Application by Esso Petroleum Company, Limited for the Southampton to London Pipeline Project**The Examining Authority's written questions and requests for information (ExQ2)****Issued on Monday 13 January 2020**

The following table sets out the Examining Authority's (ExA's) written questions and requests for information – ExQ2. Questions are set out using an issues-based framework derived from the Initial Assessment of Principal Issues provided as Annexe B to the Rule 6 letter of 5 September 2019. Questions have been added to the framework of issues set out there as they have arisen from representations, Hearings and to address the assessment of the application against relevant policies.

<p>GQ.2.9</p>	<p>The Access and Public Rights of Way Plans [AS-055] sheet 36 appears to be missing from the submitted set.</p> <p>Submit sheet 36.</p>	<p>1.1 Sheet 36 is provided as an Appendix below (Appendix GQ.2.9.1).</p>

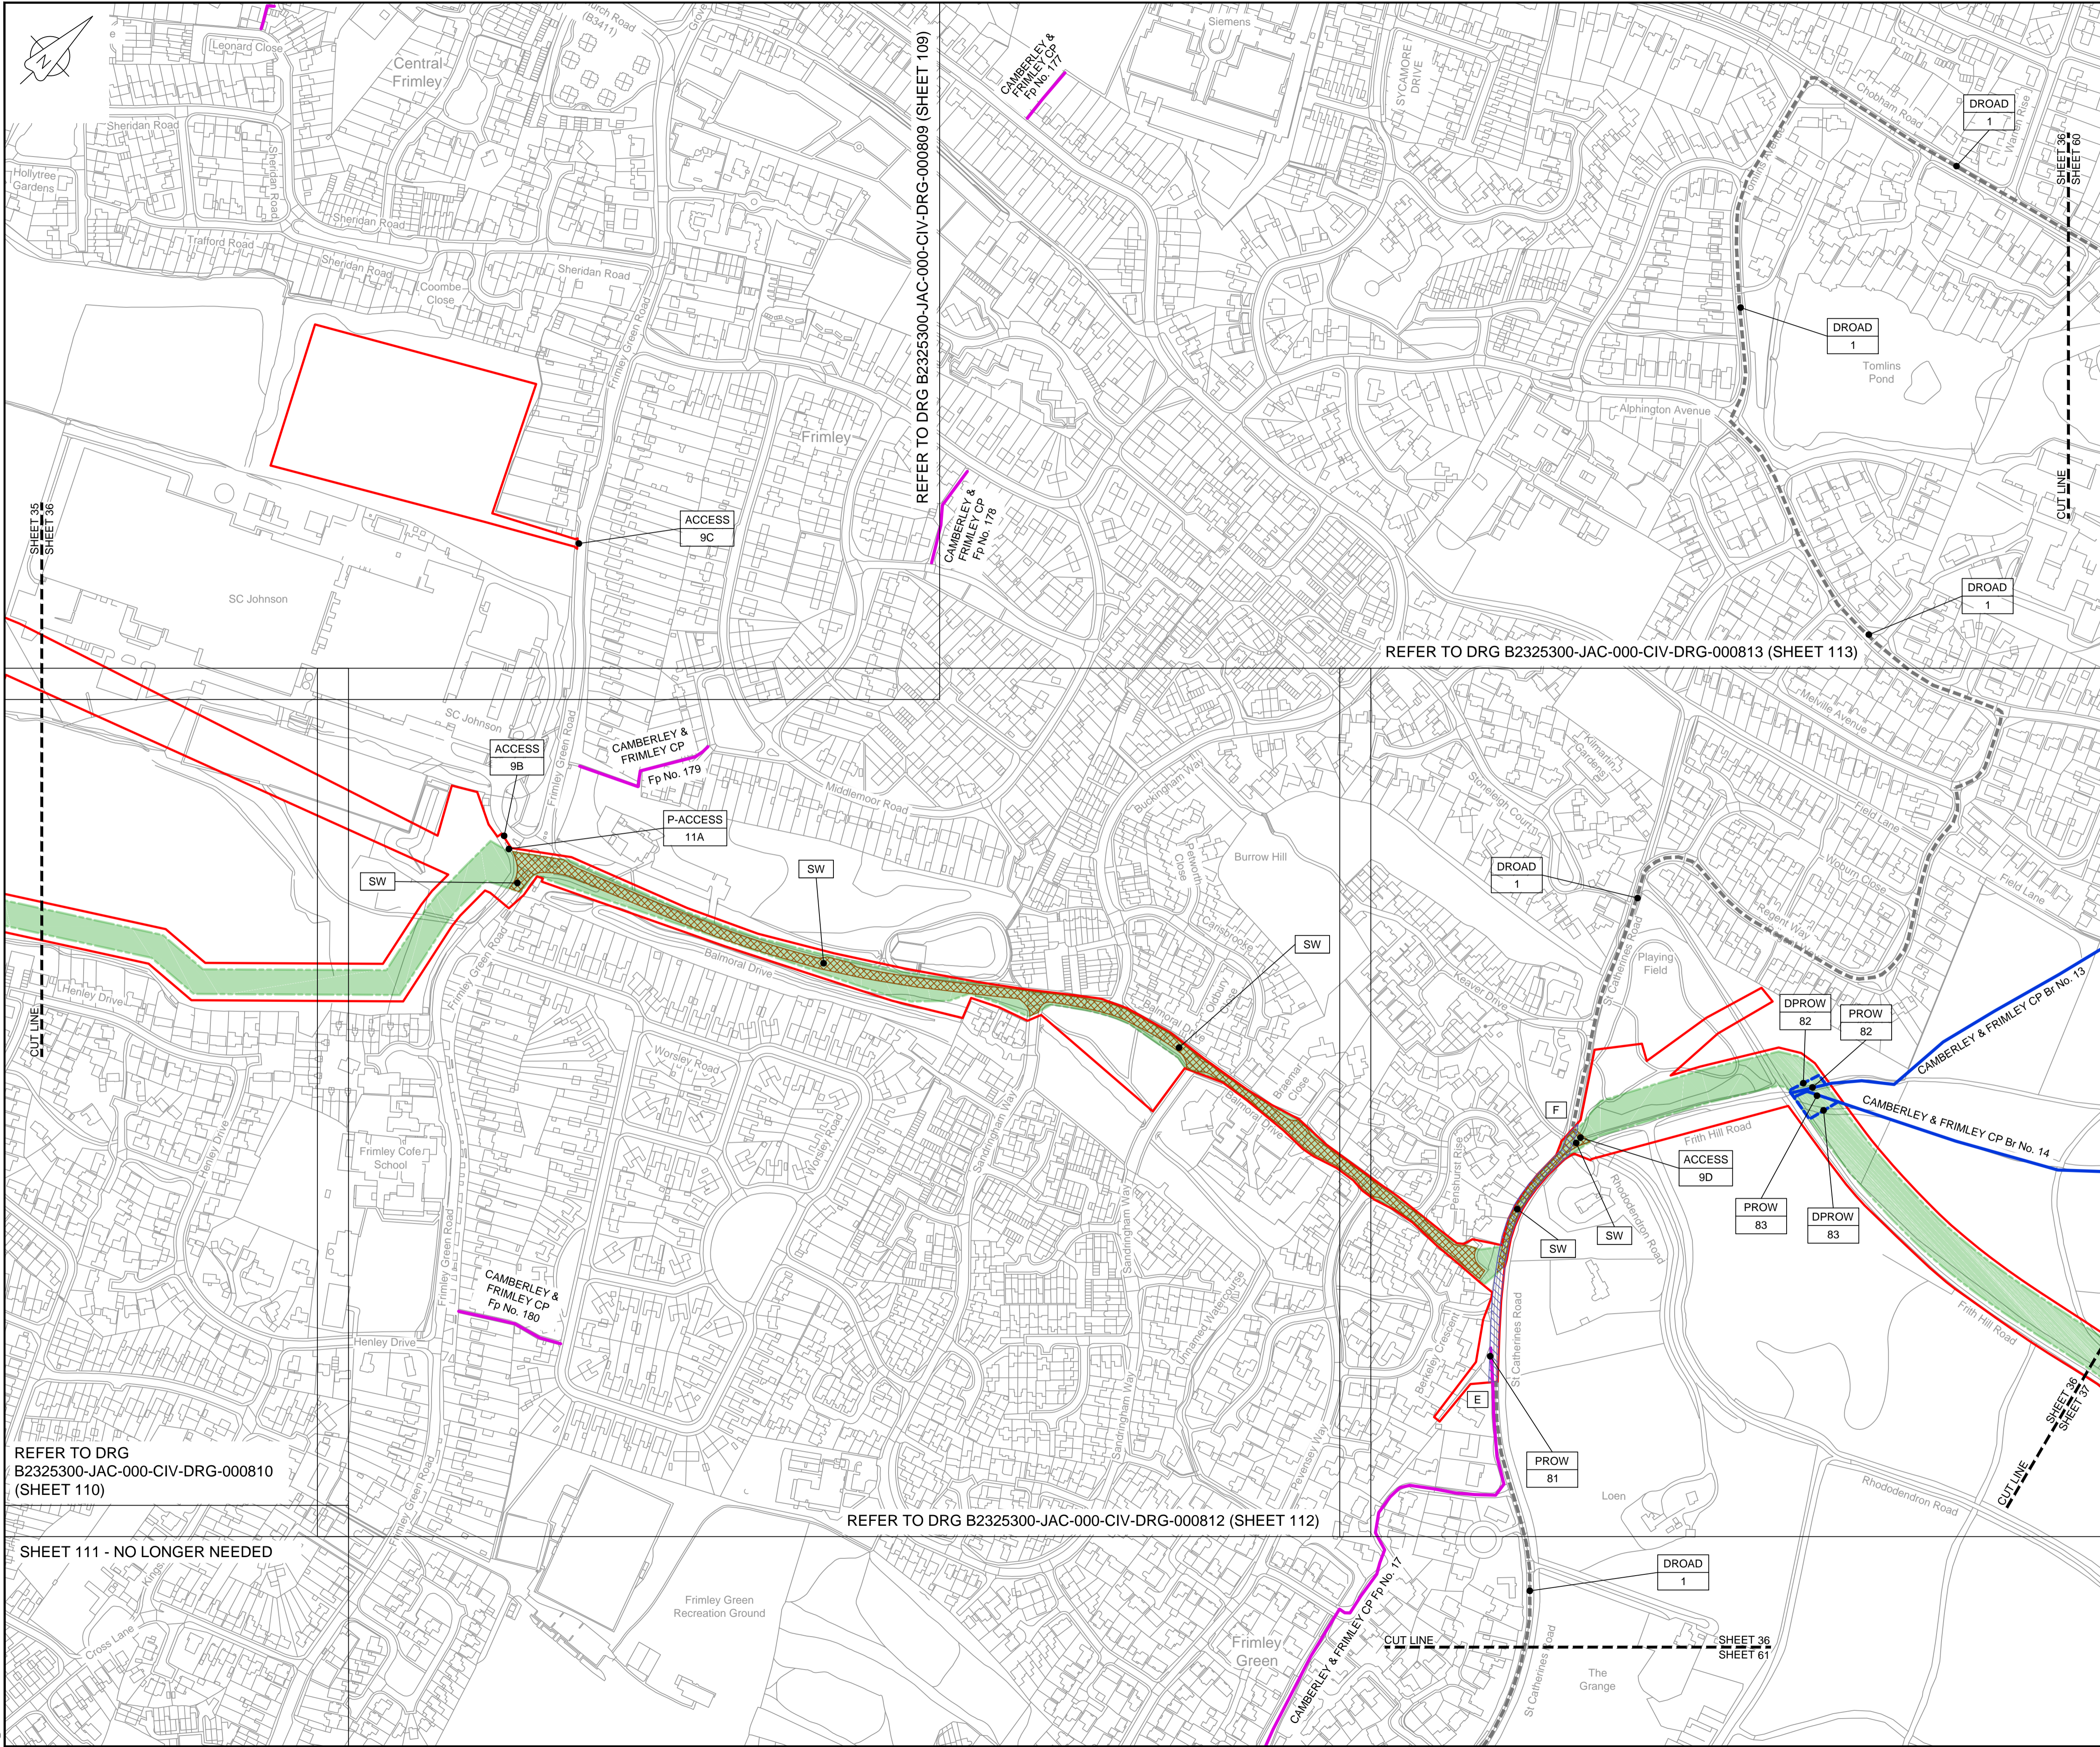
GQ.2.9	<i>Access and Public Rights of Way Plans</i> The Applicant	The Access and Public Rights of Way Plans [AS-055] sheet 36 appears to be missing from the submitted set. Submit sheet 36.
GQ.2.10	<i>Site Works and Temporary Construction Compounds</i> The Applicant	At the ISH held on Tuesday 3 December [EV-009a] and [EV-009b], the Applicant confirmed that site works, and the temporary construction compounds were required for a period of up to two years. The Applicant's response to Action Point 18 [REP3-013] also confirmed that work within SANGs and within Queen Elizabeth Country Park would not extend for more than two years. Signpost and confirm where and how this is secured in the dDCO [REP3-006].
